Job No. 193940

July 24, 2026

Re: Response to:
Colorado Geological Survey Review Comments, dated December 22, 2025
Triple H Ranch
EPC Schedule No. 3300000168 and 3300000388
El Paso County, Colorado

TEST PIT
 LOCATION PLAN

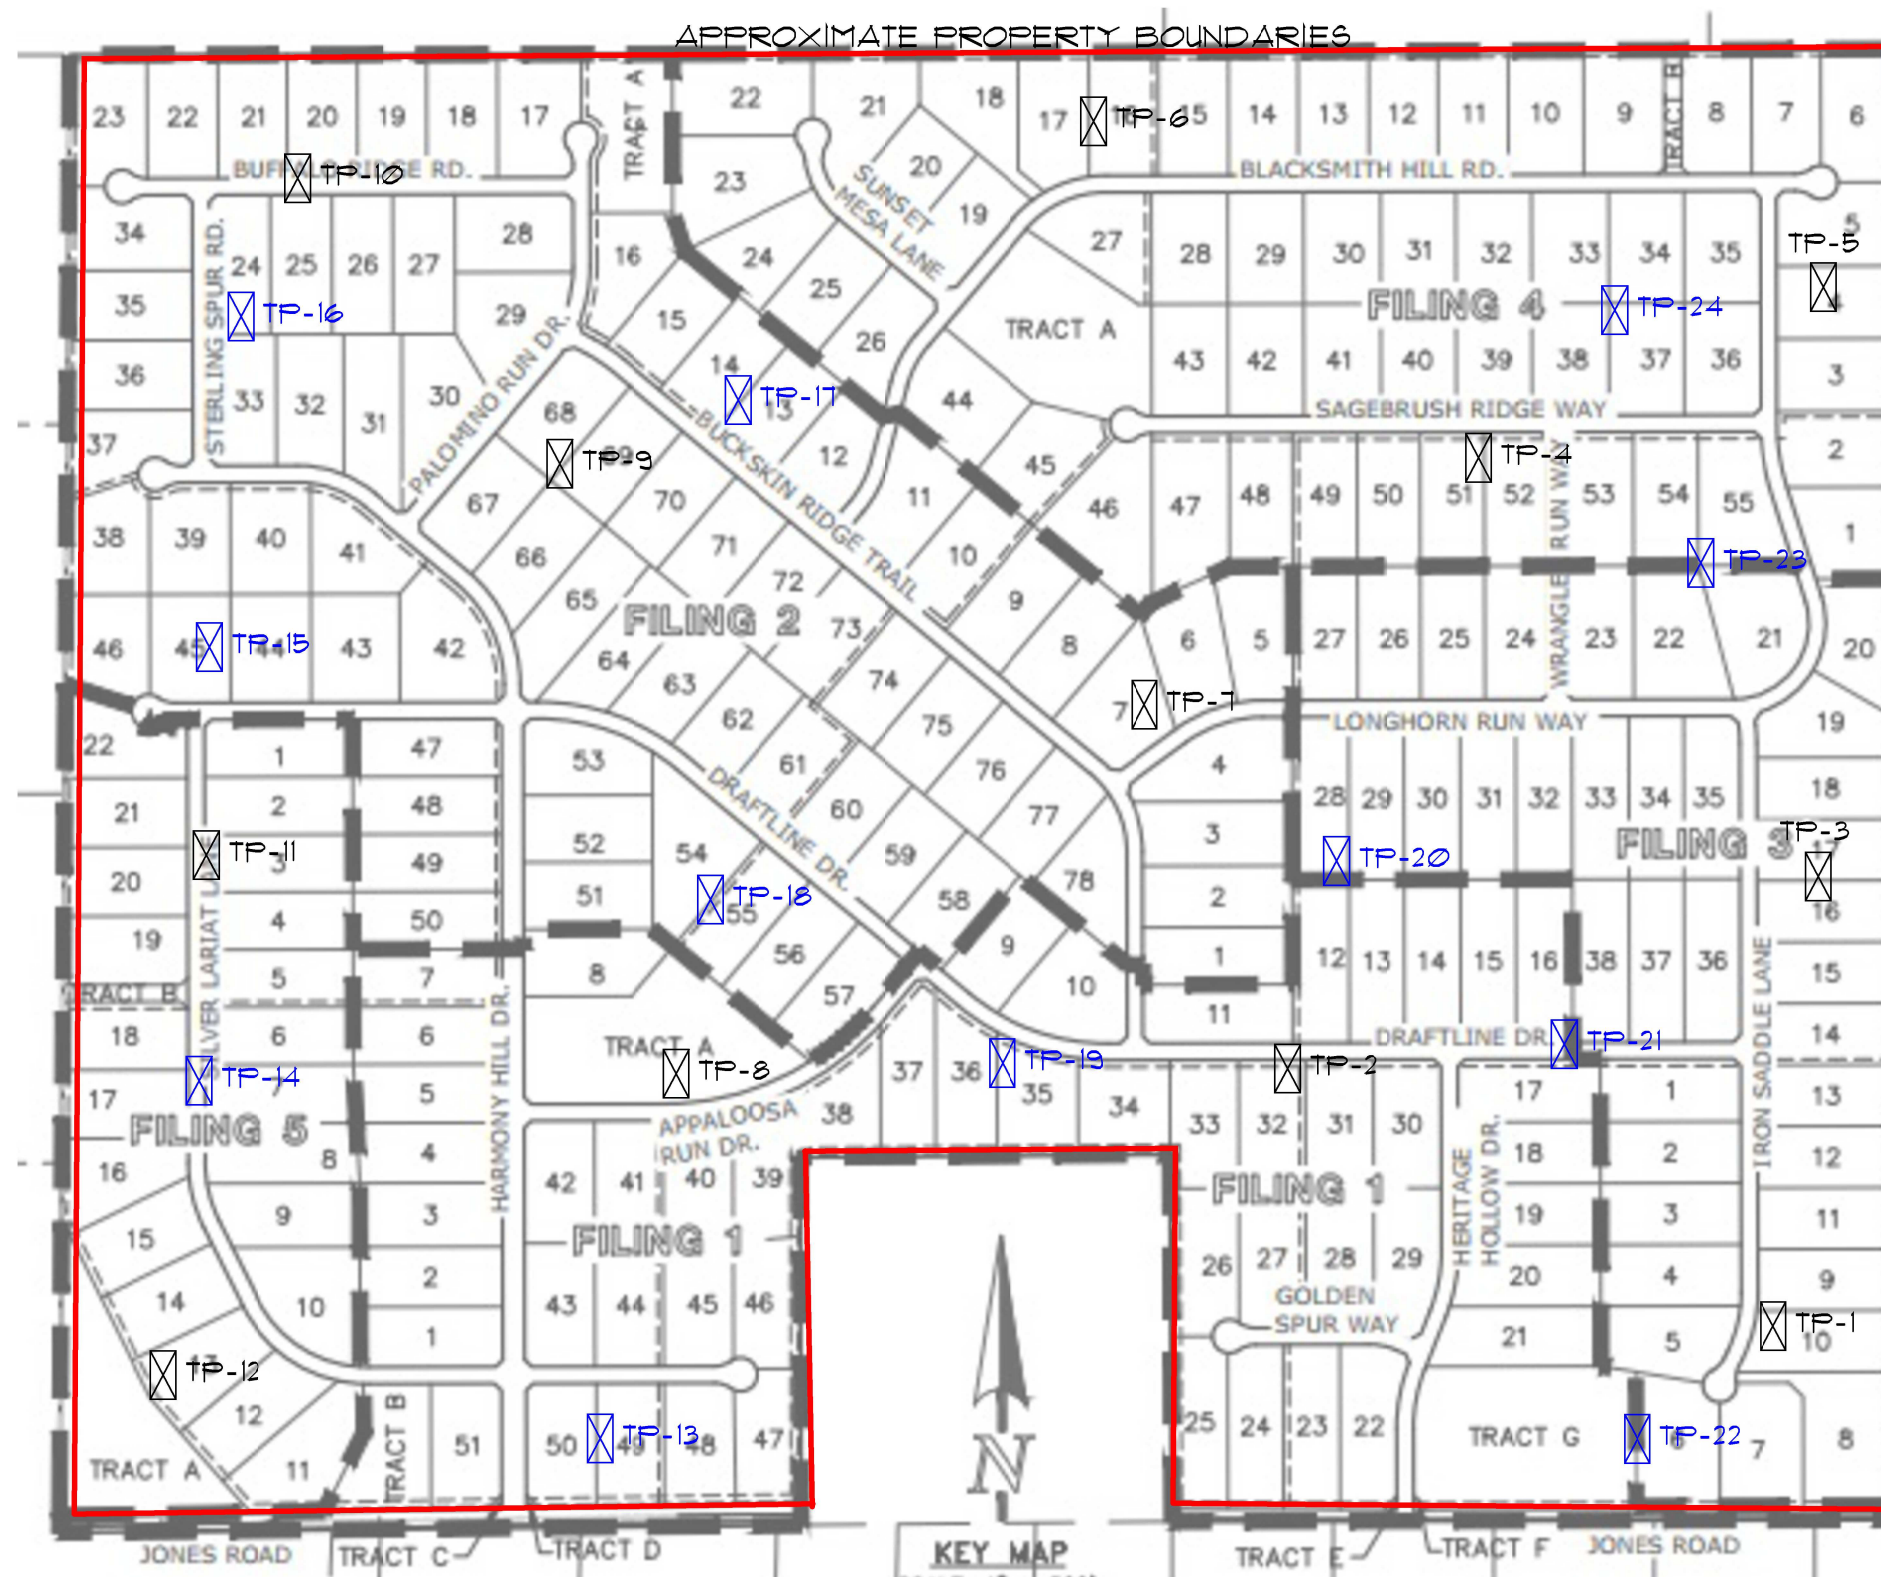
Additionally, it is our understanding Public Health acknowledged OWTS feasibility, based on our work but noted that some of the OWTS may require engineered designs due to limiting soil conditions. It was recommended that RMG confirm whether the amended Wastewater Study and OWTS Suitability Map adequately address this and match the current preliminary plan.

Figure 16, Septic Suitability Map, within our Wastewater Study, last dated July 24, 2026 denotes two approximate locations for future proposed OWTS (systems) for each lot included in the subdivision. Of the 24 test pits RMG observed at the site (12 test pits in 2023 and 12 test pits in 2026), we had one test pit (TP-07) that encountered sandstone at a depth of 7 feet. The sandstone bedrock is considered a limiting layer. Other factors, such as very slow or very fast LTAR values, can also result in a requirement for the OWTS to be engineered.

The requirements for engineered systems cannot be determined on a lot-by-lot basis using the data available today. OWTS Site and Soil Evaluations are to be performed on each individual lot prior to construction. The requirement for an engineered system is to be determined at that time, based on the soil conditions encountered in the proposed OWTS location for that lot.
